From: [REDACTED]
Sent: 15 September 2022 10:46
To: 'planning@ribblevalley.gov.uk'
Subject: Planning application 3/2022/0568 land to the rear of Malt Kiln House.
Attachments: Planning comments sheet 1.pdf.jpeg; Planning comments Sheet 2.jpeg; Planning comments Sheet 3.jpeg

3/2022/0568

Land to the rear of Malt Kiln House.

PROJECT				
Proposed Residential Development at Malt Kiln Brow, Chipping.				
DRAWING TITLE				
Flex MSE Retaining Wall Proposed Section				
DATE	SCALE	DRAWN	DRWG No.	REV
Dec 2022	1:25	GEGH	SKETCH01	A

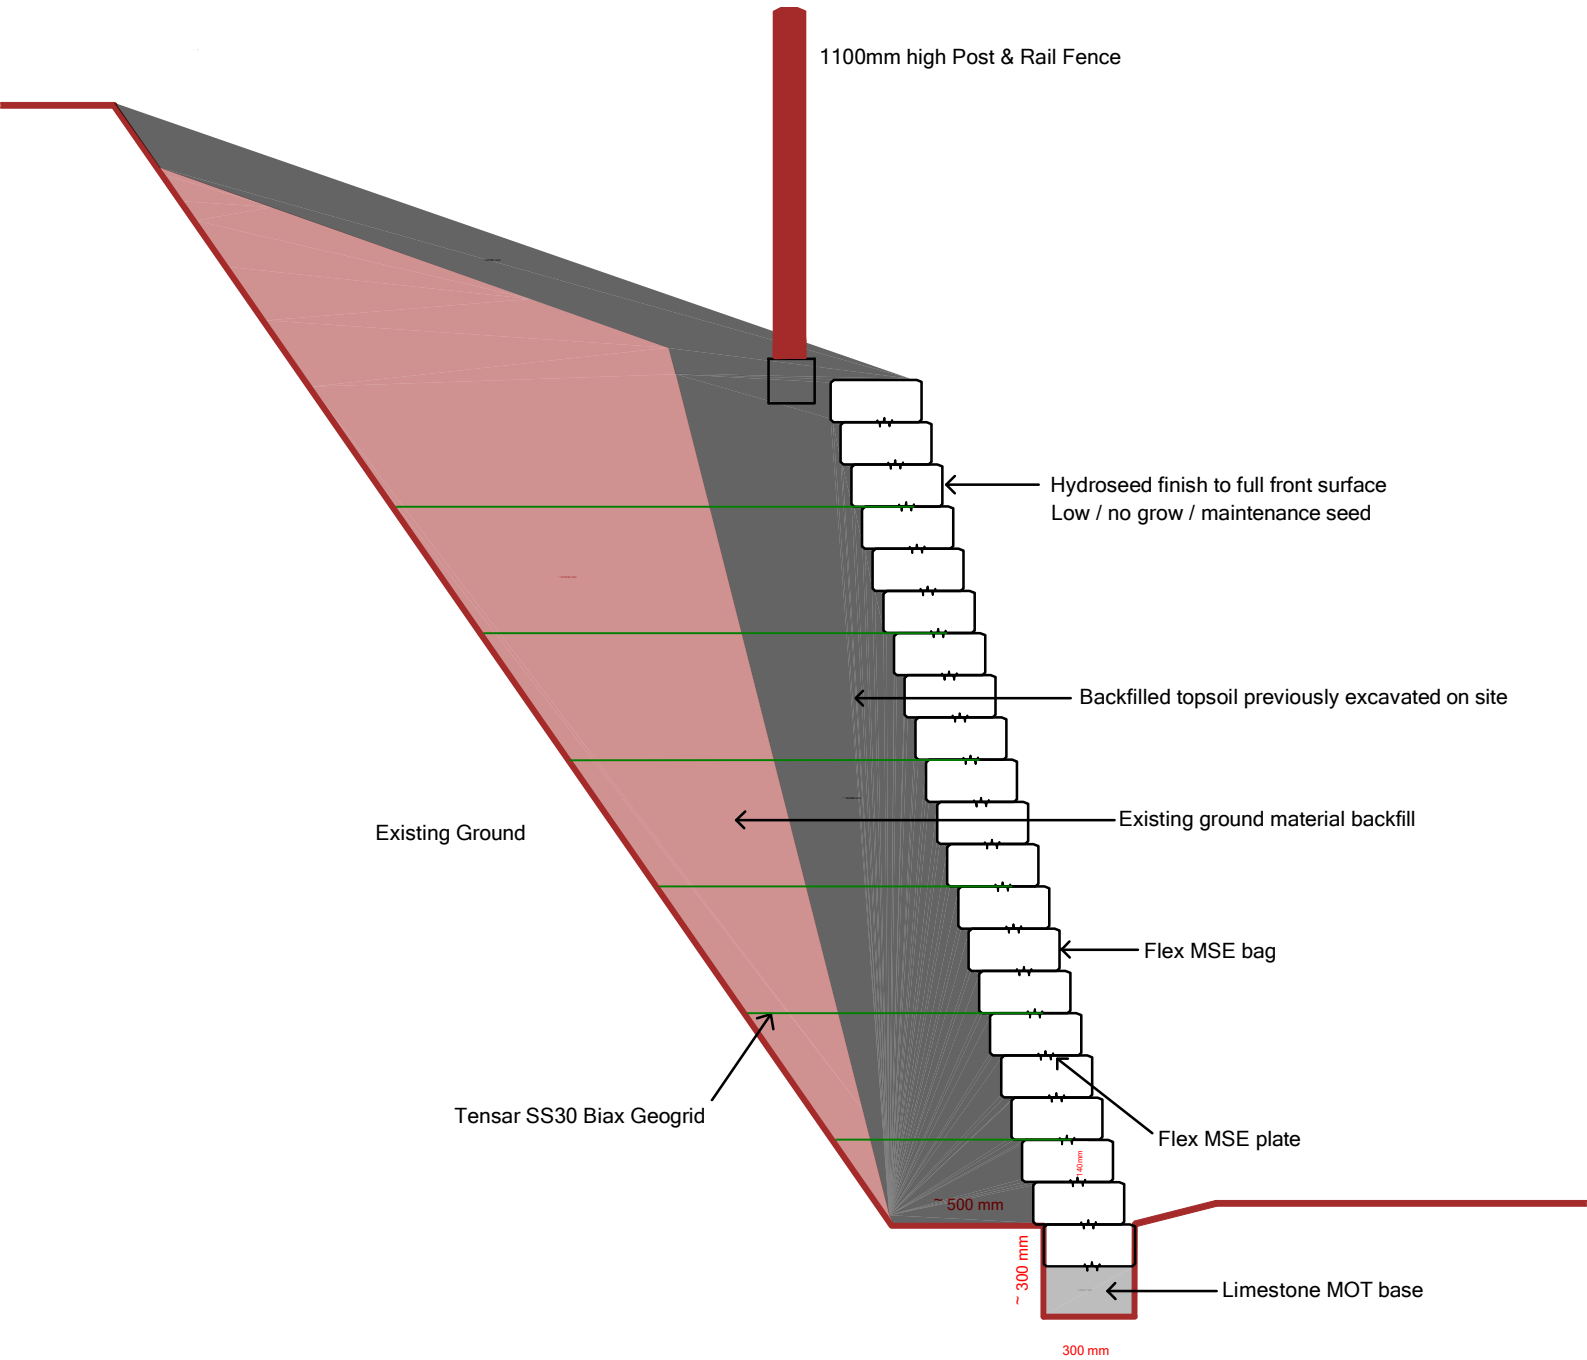
6. Trees on the site are not being adequately protected. For example T1 on the tree survey is shown as a very large mature Beech tree in excellent condition on the northern boundary. The Root Protection Area has been shown but earthworks and the "green" sandbag retaining structure is being built on top of it. Root Protection Areas should be fenced off and protected from disturbance. Likewise the trees located on the western boundary. For example T9 Common Lime again deemed as excellent specimen, has proposed retaining wall to be built right on the edge of the Root Protection Area. You cannot build the wall itself without excavating backwards into the RPA.

PROJECT				
Proposed Residential Development at Malt Kiln Brow, Chipping.				
DRAWING TITLE				
Traffic Management Plan.				
DATE	SCALE	DRAWN	DRWG No.	REV
June 2022	1:500 @ A3	SDH	MKB/P03	C

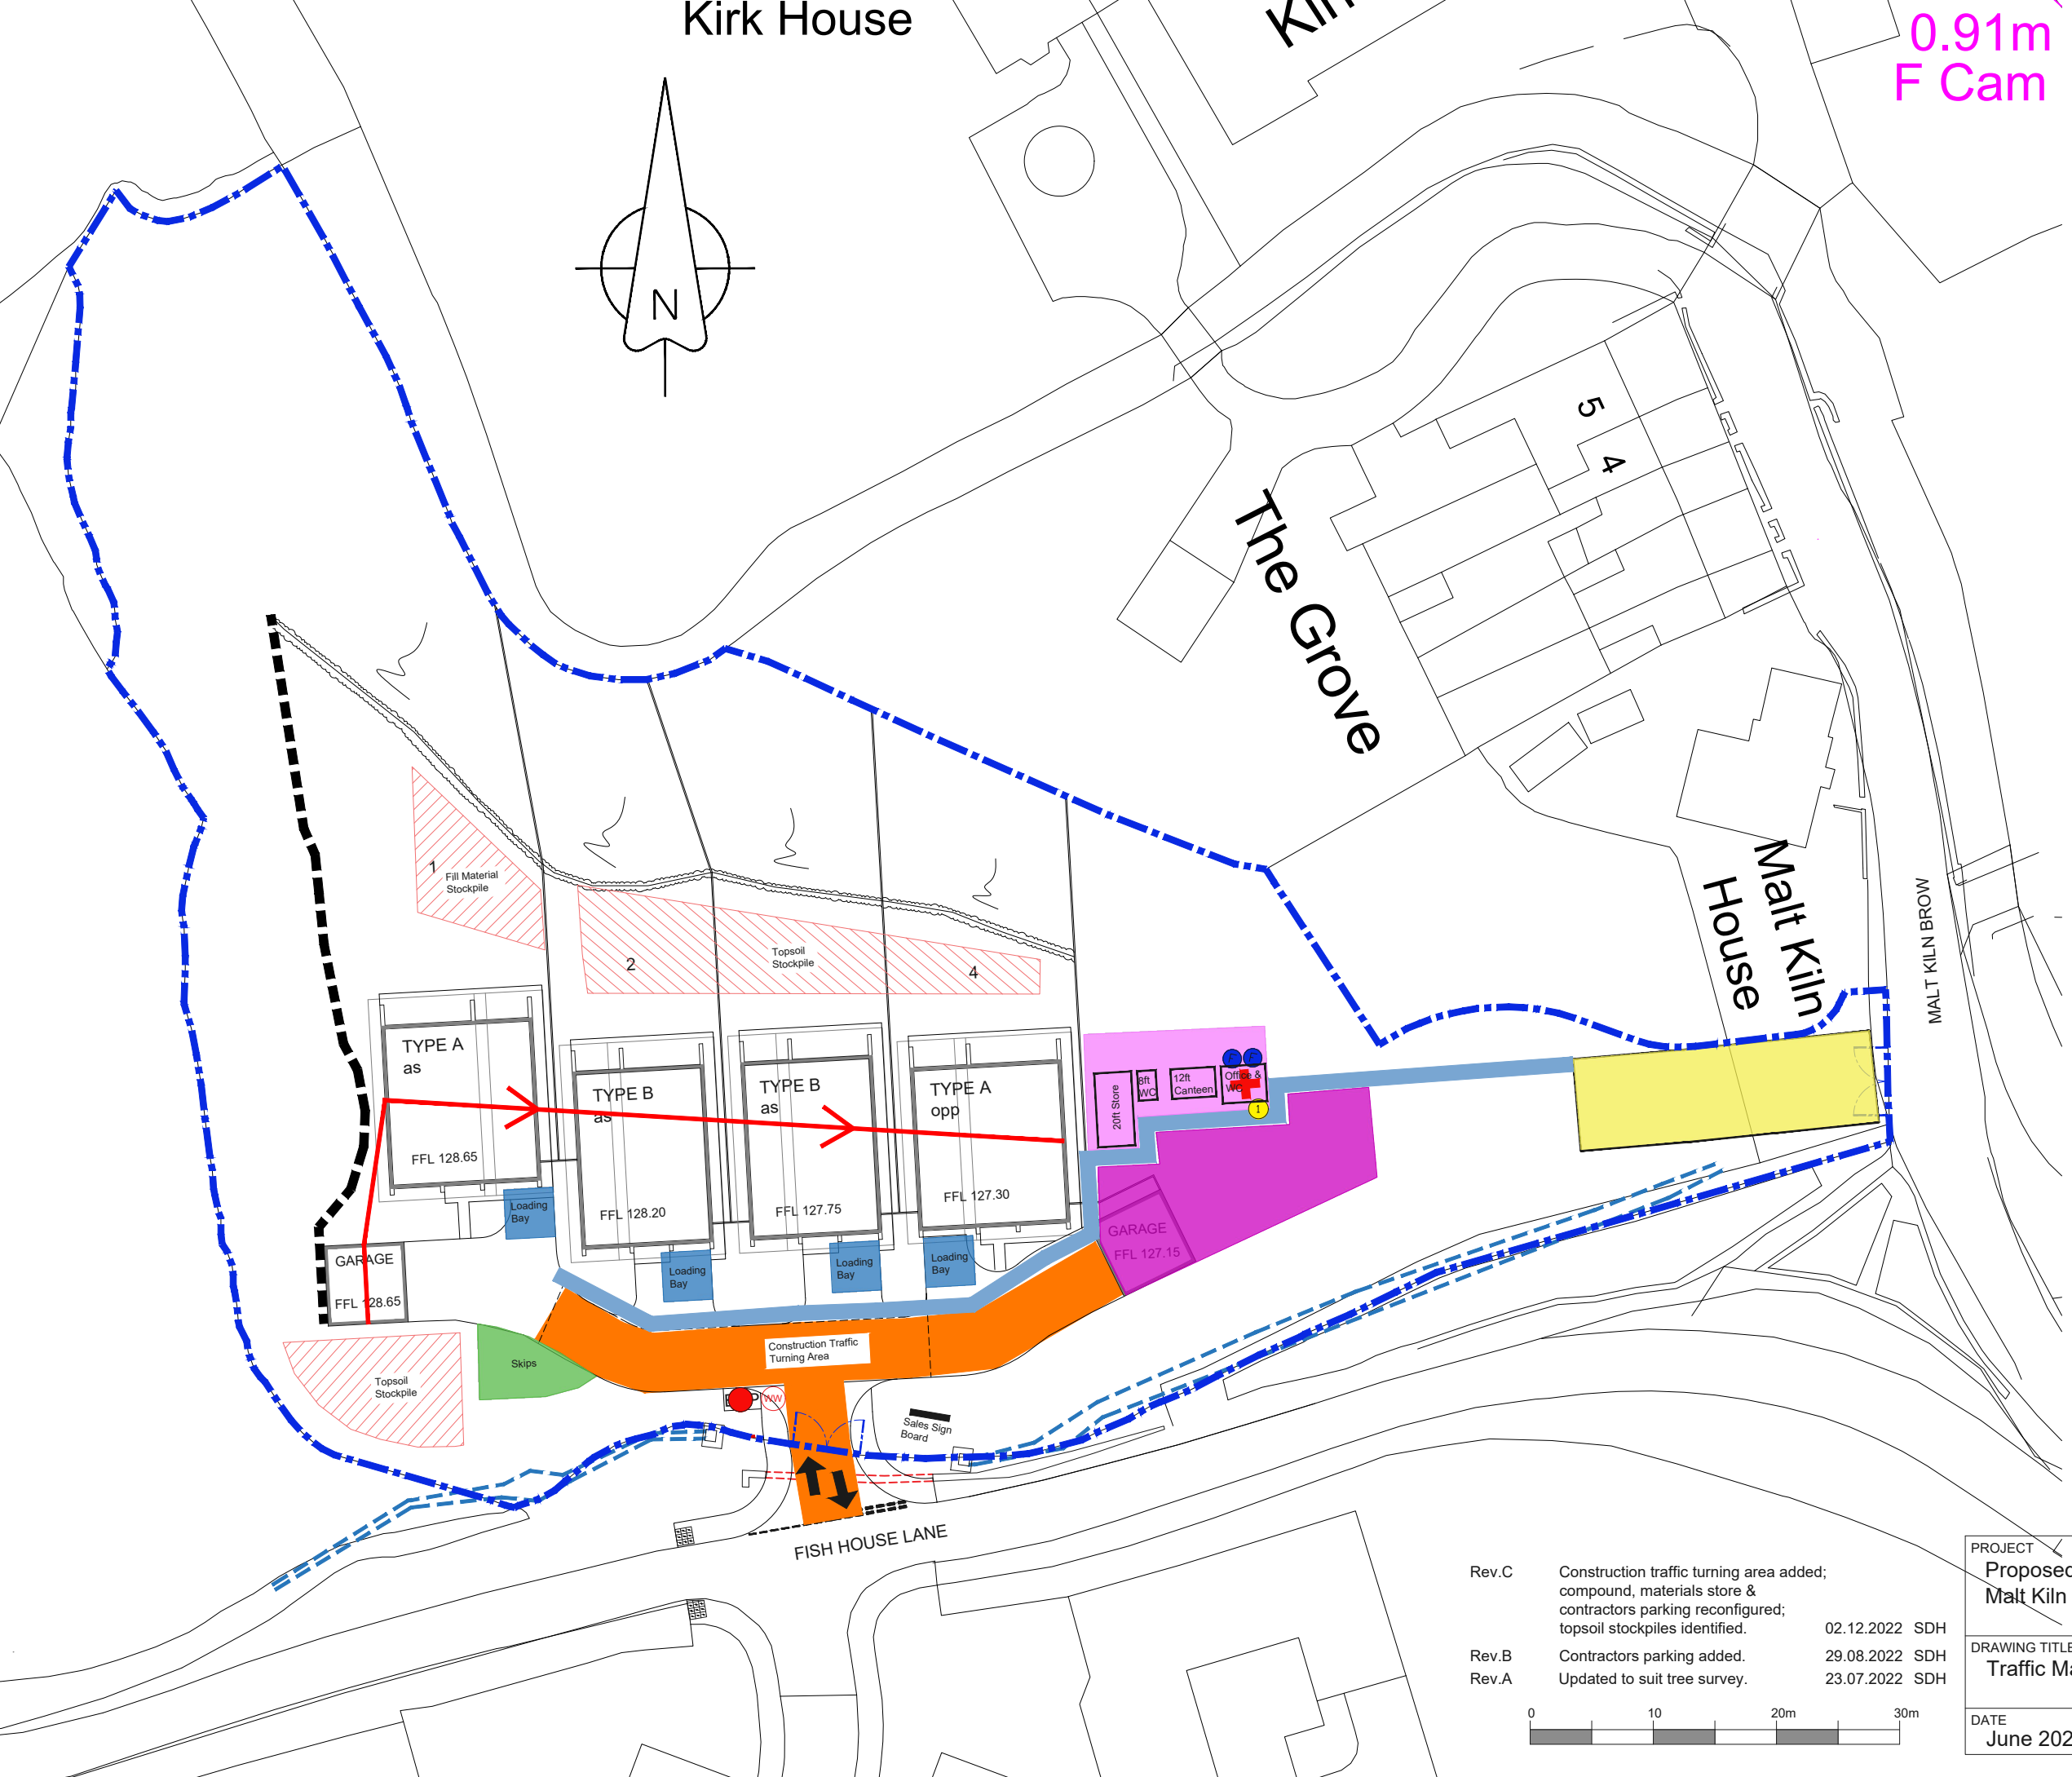
4. The traffic management plan shows that an entrance and haul road for construction purposes will be built in the gap between the garden of Malt Kiln House and the culverted watercourse. For this, excavators will be required to remove topsoil and import and spread crushed stone to form the temporary road. There does not appear to be room to do this. I cannot see how this can be done anyway without causing serious environmental damage. During construction there appears A new permanent access is proposed onto Church Raikie almost opposite the existing entrance onto the Fellside development. This is a new proposal which will increase traffic still further on this narrow lane which has no footway on either side. The way that the site entrance has been moved from Malt Kiln Brow, on the previous application, appears to be an admission that the access is unsuitable. If it is deemed unsuitable for a permanent access then it must be unsuitable to form an access and haul road capable of taking heavy construction traffic. I don't believe that heavy, fully- loaded vehicles of construction materials seriously be capable of gaining access to the site via a haul road from Malt Kiln Brow?

5. I don't believe that there is sufficient room for materials storage and parking on site during construction. It is most likely that construction traffic will park on the Fellside development and Church Raikie. This is totally unacceptable.
